ATP Locomotive Workshop (Bays 5 - 15) (SSD-8449-Mod-4)
Request for Additional Information

I refer to the modification application for alterations to the internal design and layout of Bays 5 – 15 of the Locomotive Workshop (SSD-8449-Mod-4).

Schedule 1 – Additional information

drawing title
INTERTENANCY WALLS
INTERNAL - ELEVATIONS / SECTION
(QUANTIUM & HOIST)

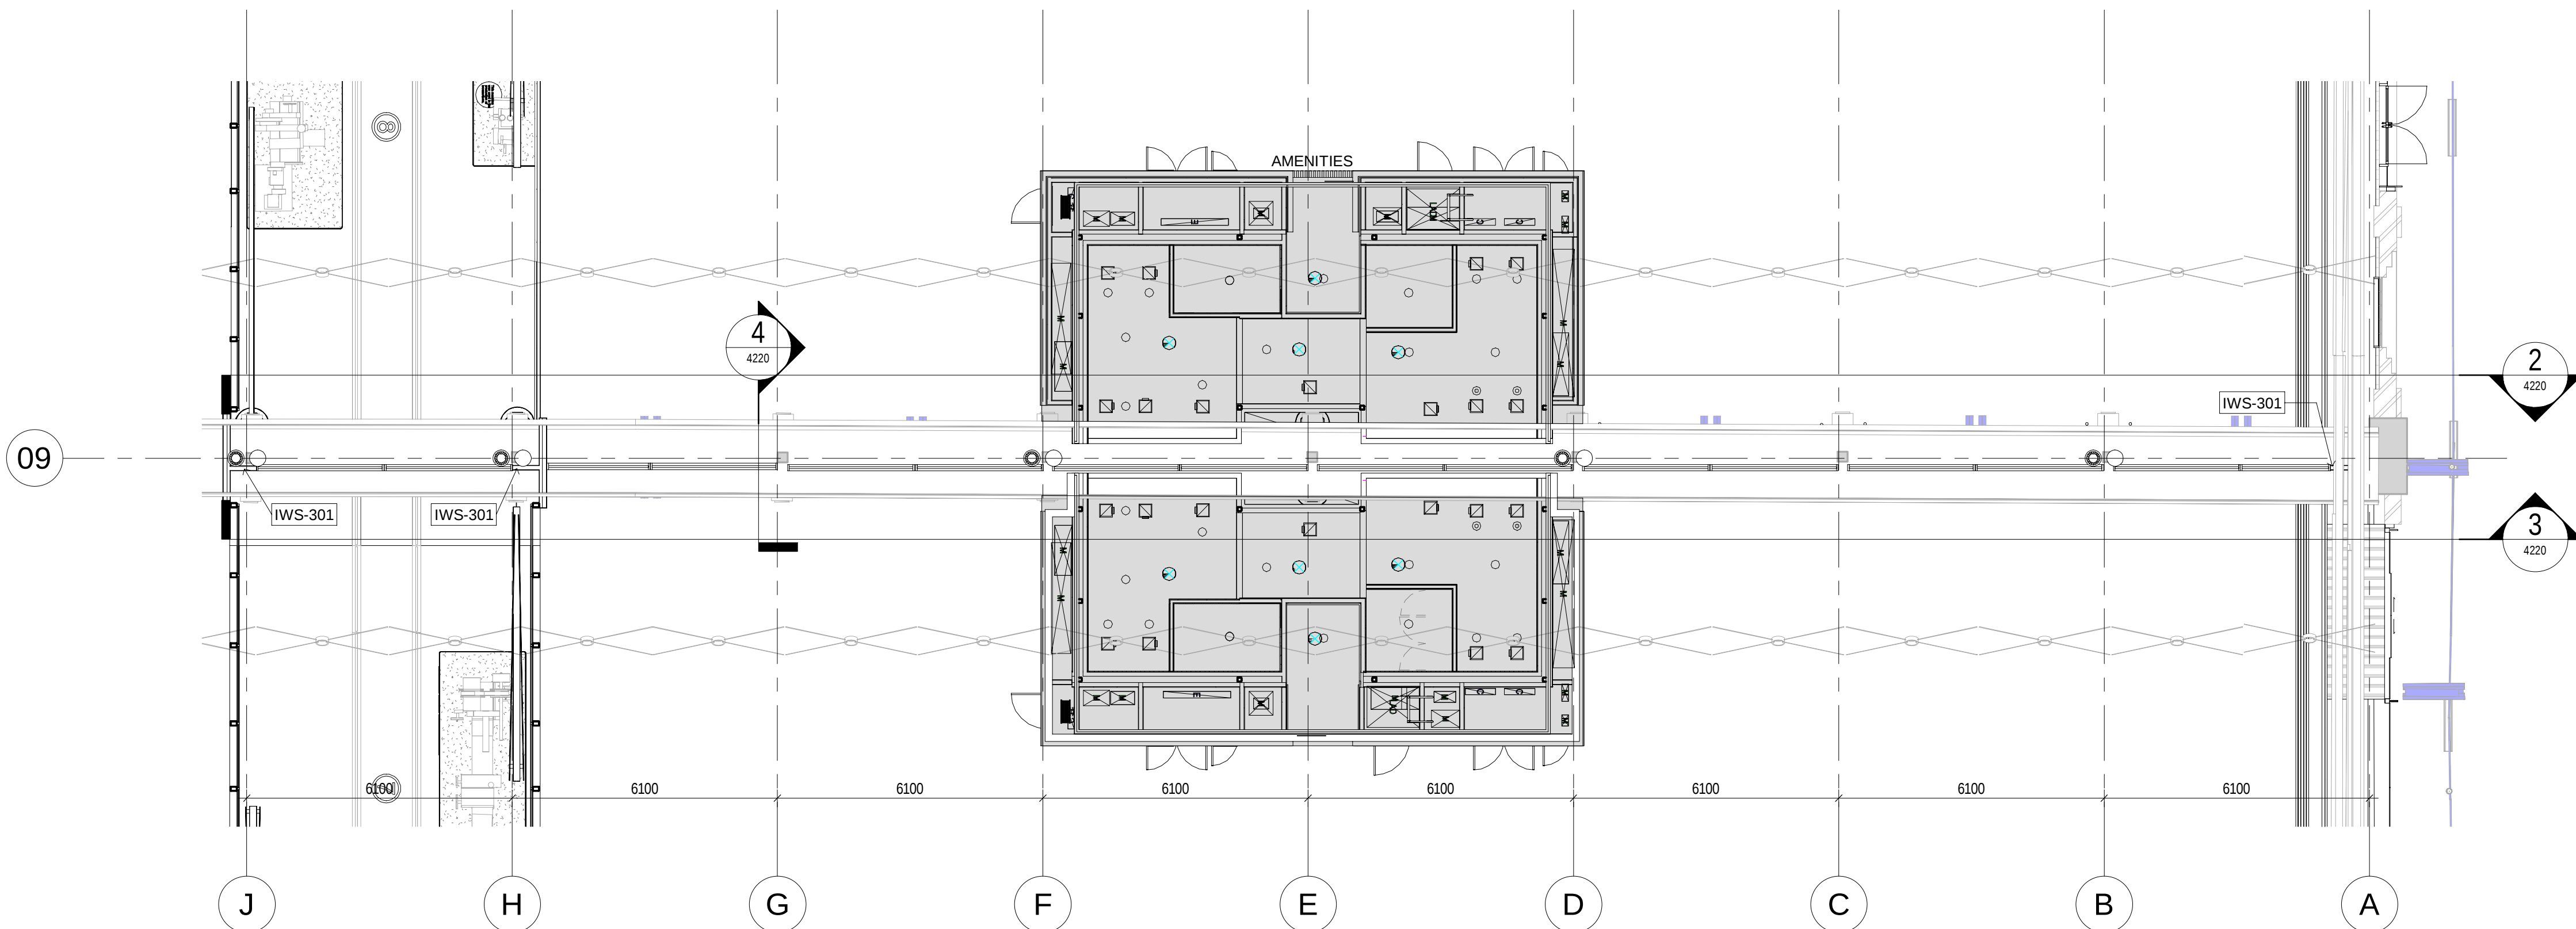
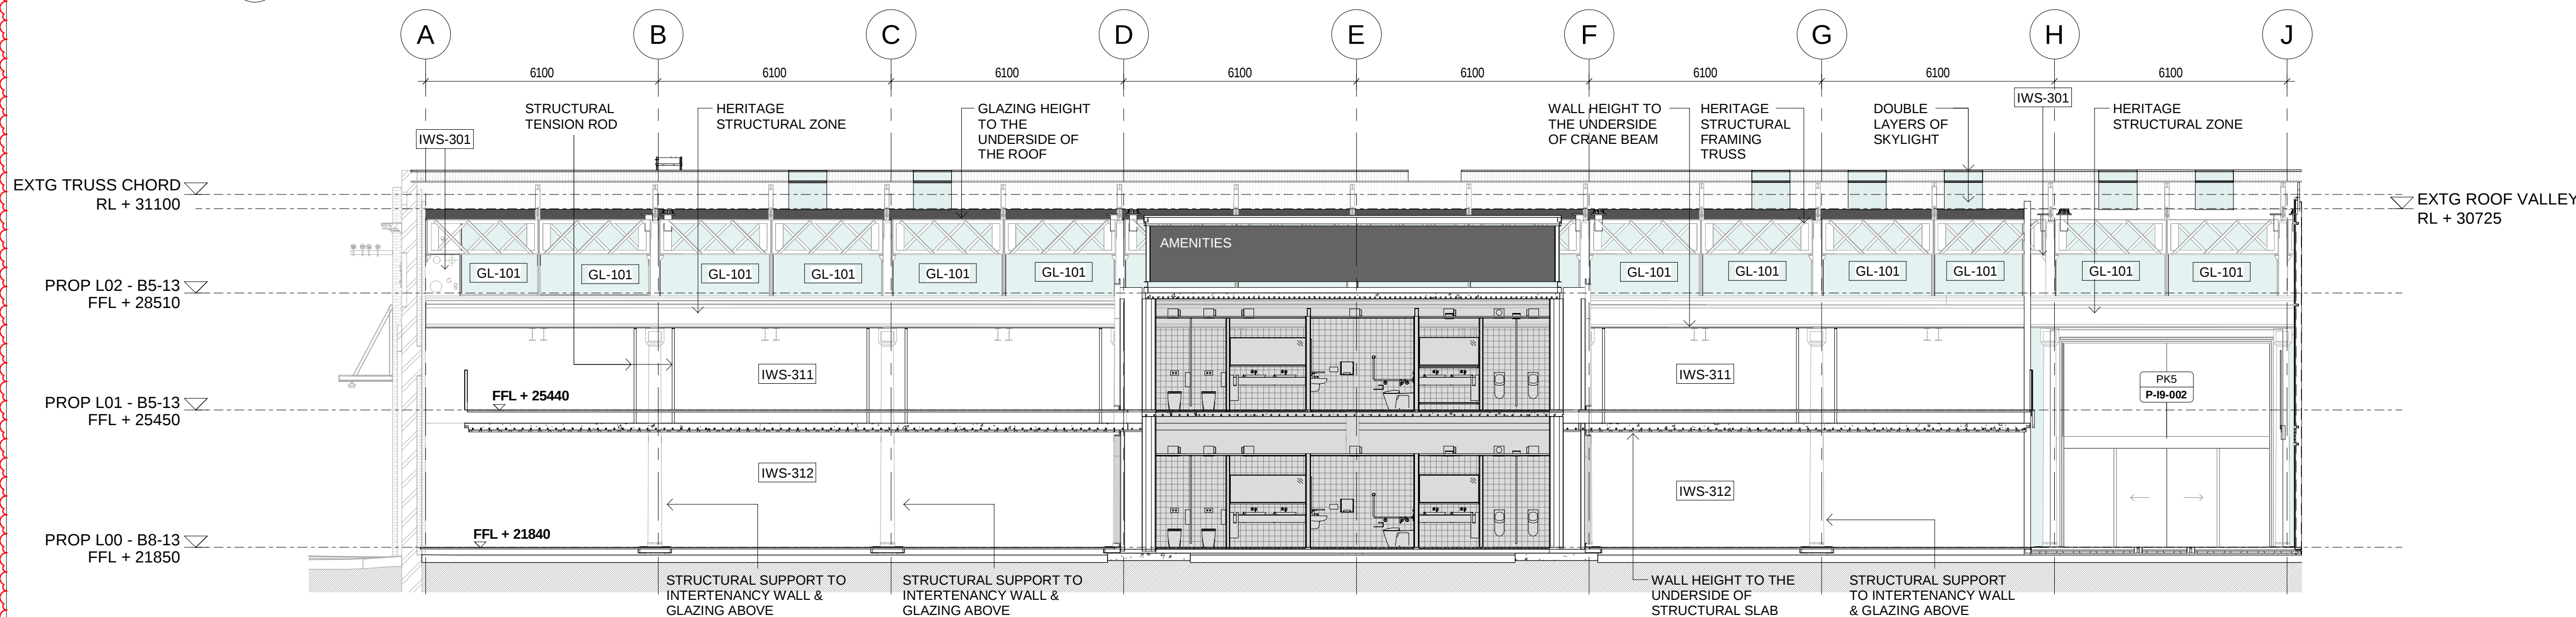
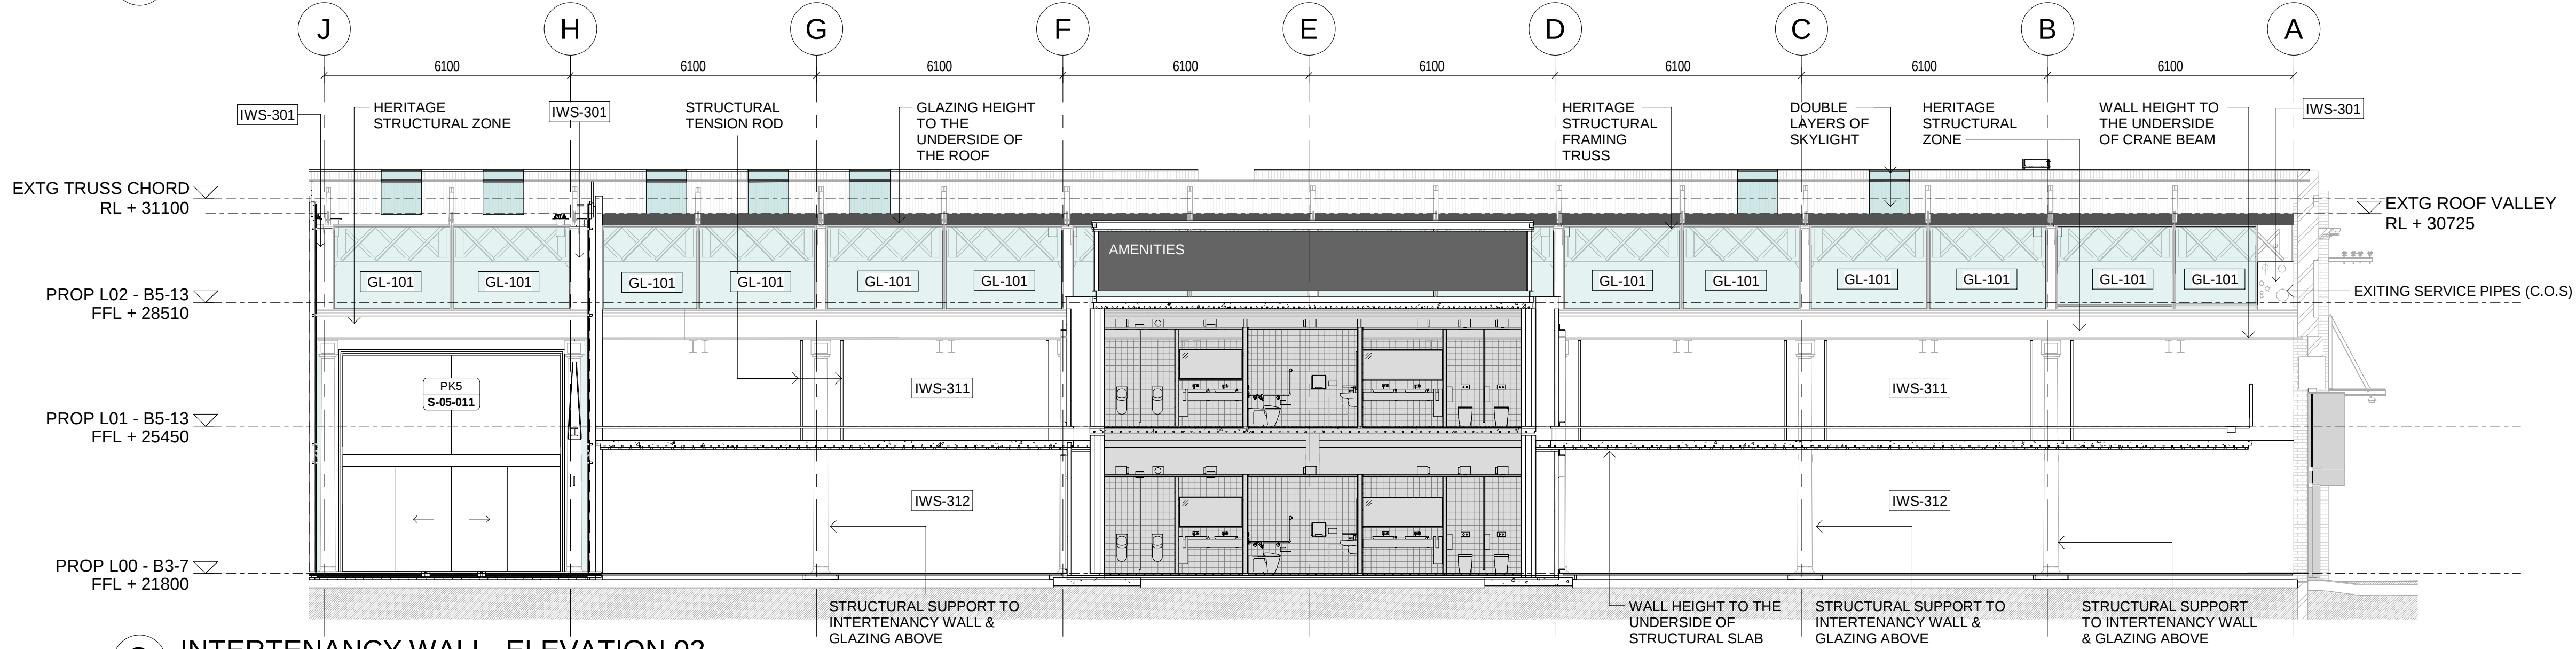
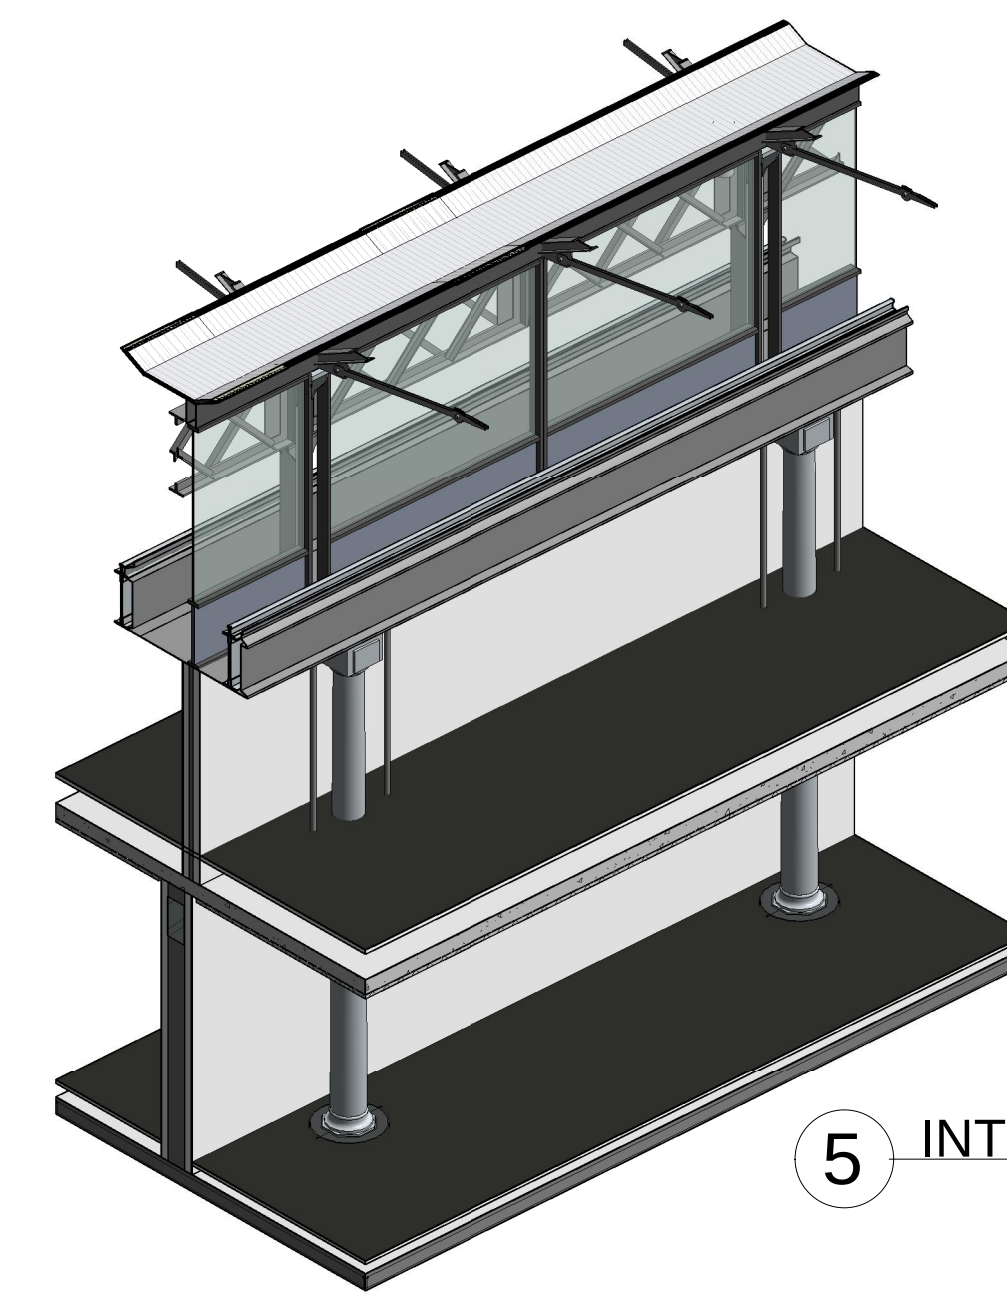
- Identify the material proposed for the intertenancy wall that is proposed to be moved from gridline 9 to 10 (item 14).
- Confirm the GFA calculation changes from approved plan, SA-AR-DWG-BB-B4-0250 Rev T, to the submitted plan, SA-AR-DWG-BB-B4-0250 Rev U.
